Our Ref: EP/157/18/HH
Your Ref:

Town & Country Planning Act 1990 (as amended)
Town & country Planning (Development Management Procedure) (England) Order 2015
Application for Planning Permission for Works or Extension to a Dwelling

Development Single storey side/rear extension.
Location 103 Roundstone Drive East Preston

SIDE ELEVATION (EAST) 1:50 RT A1.

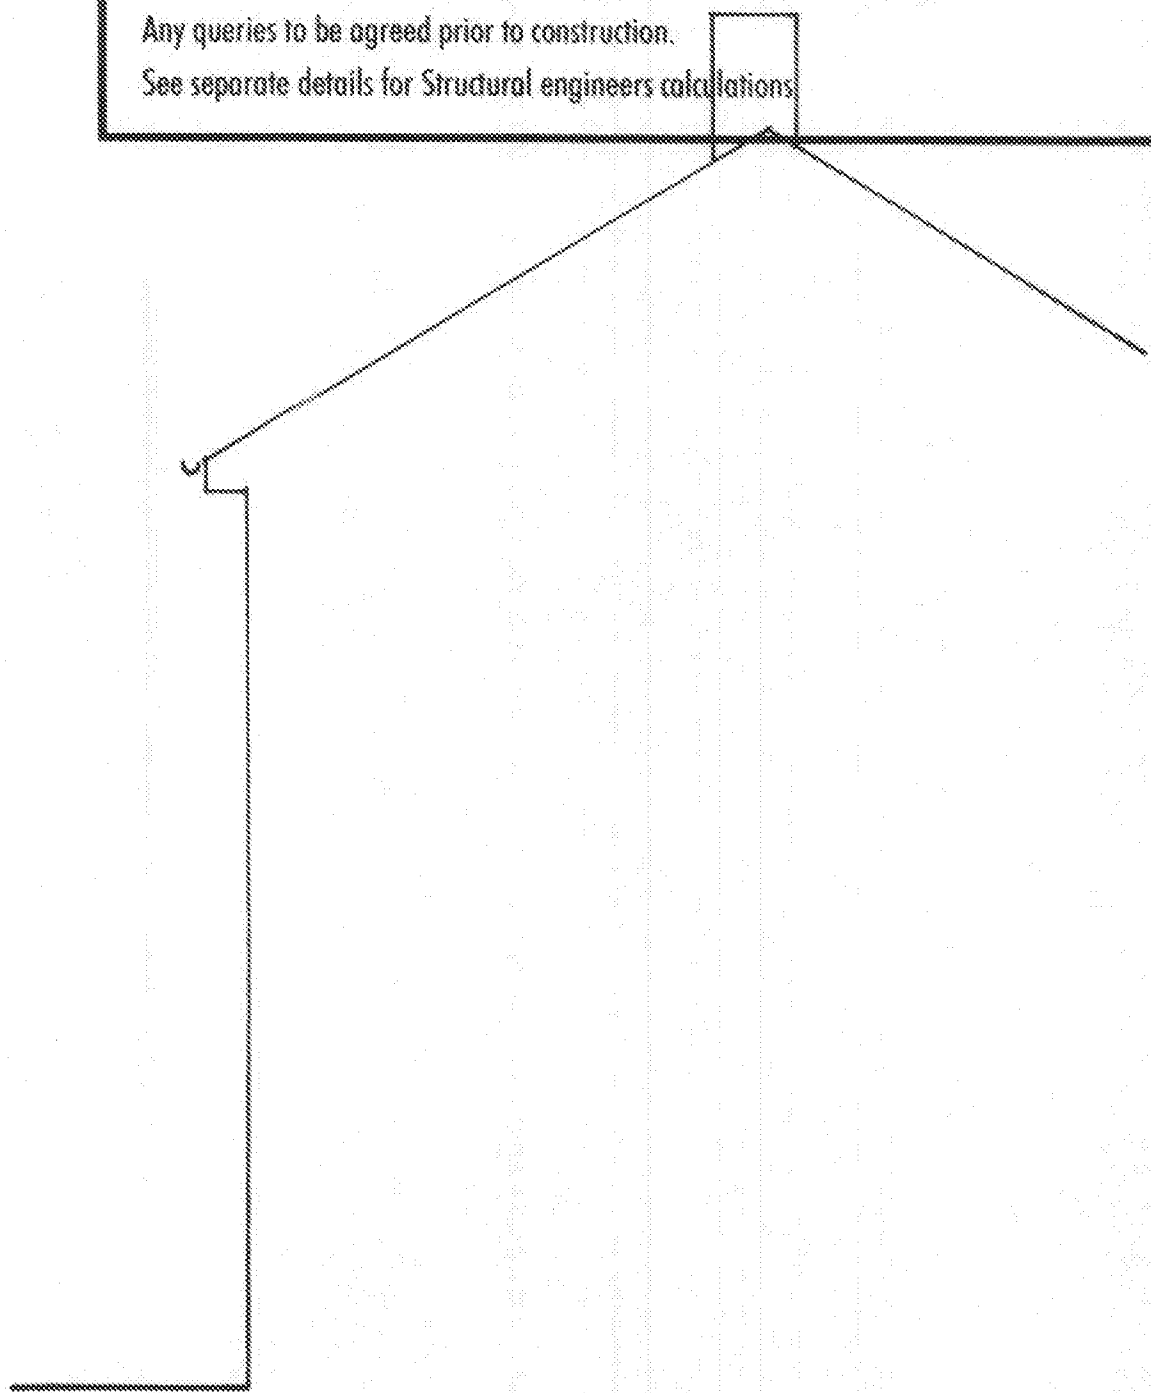
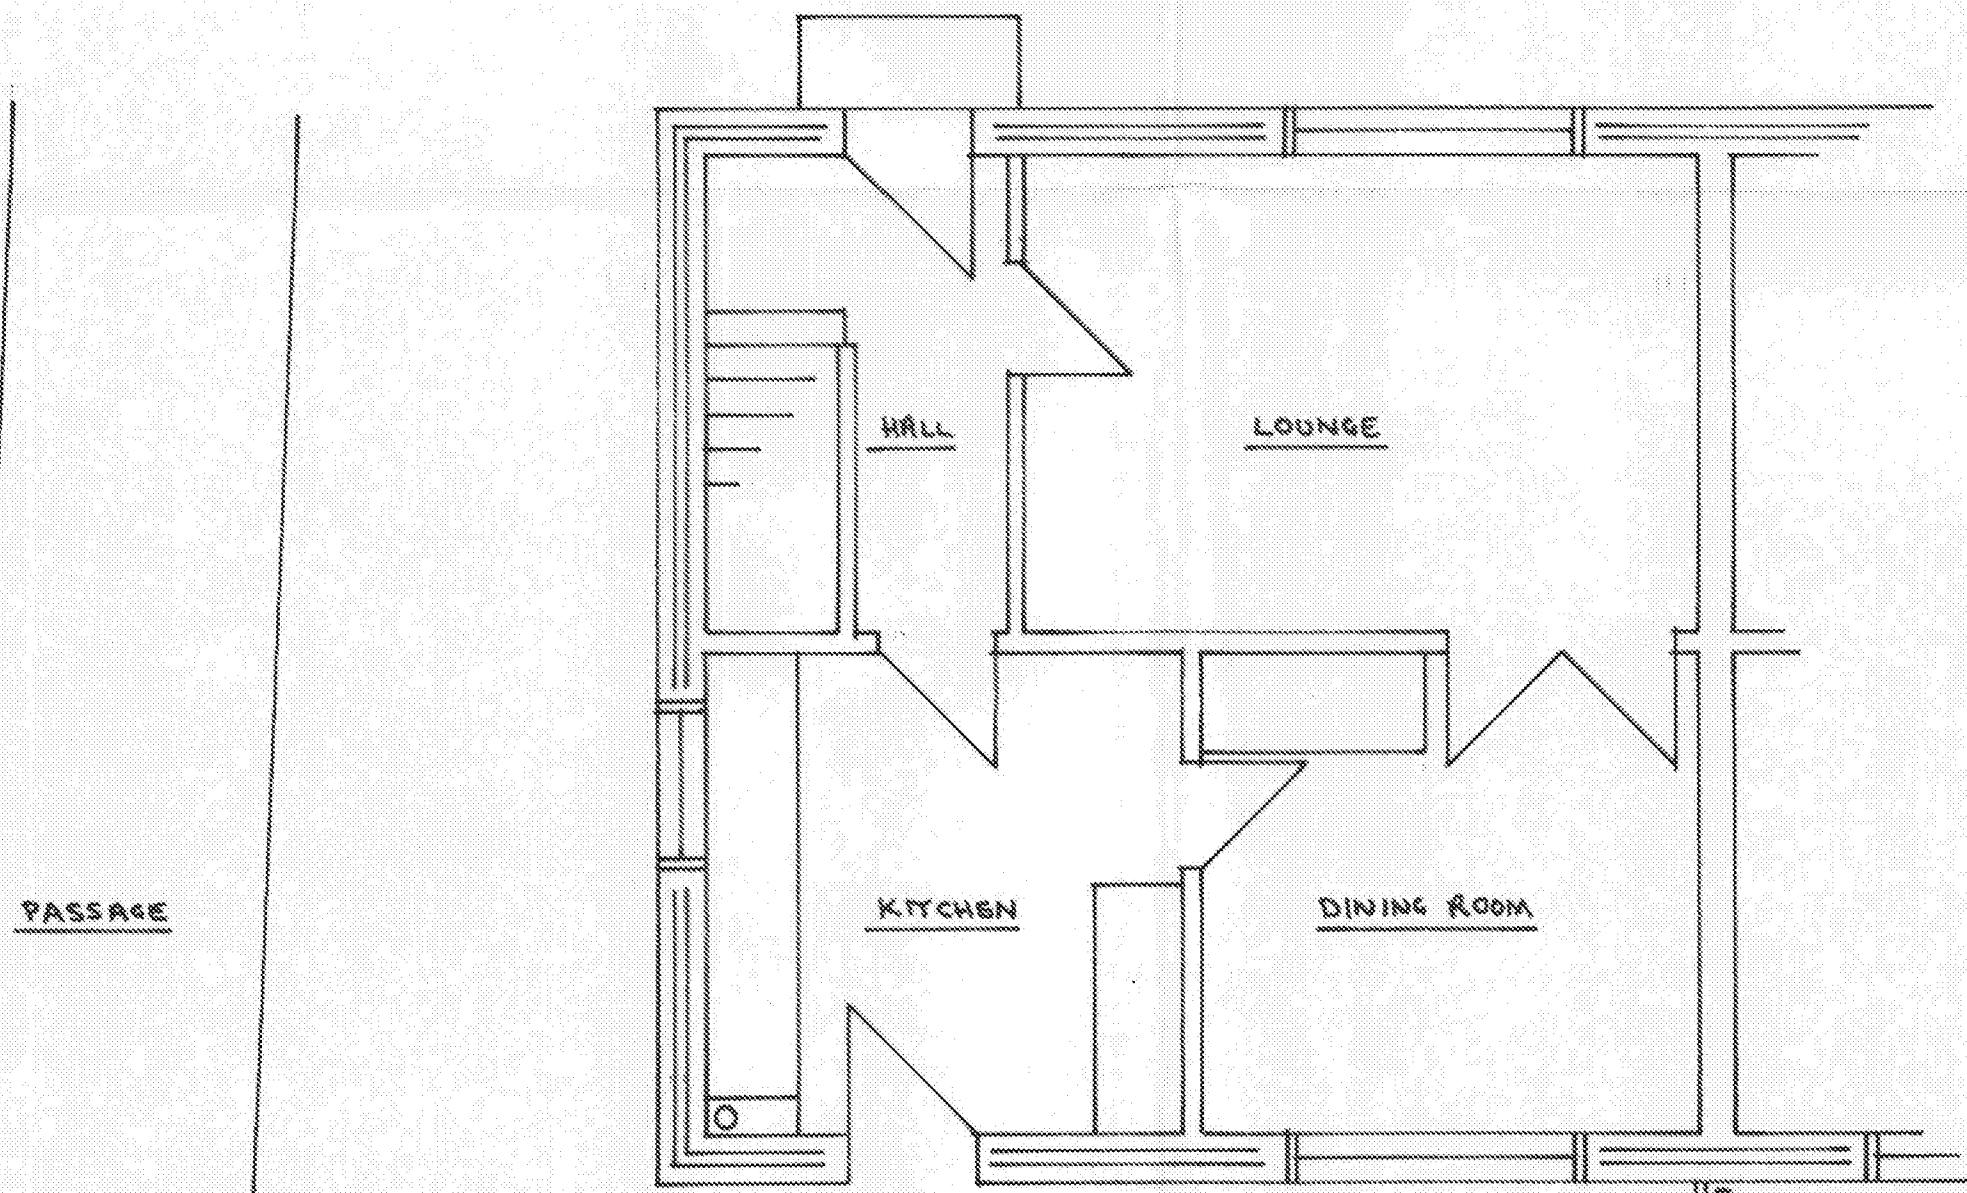
The existing east ground floor plan and elevation do not accord. Please amend accordingly. Please provide either 3 paper or 1 electronic copy of the amended plan.
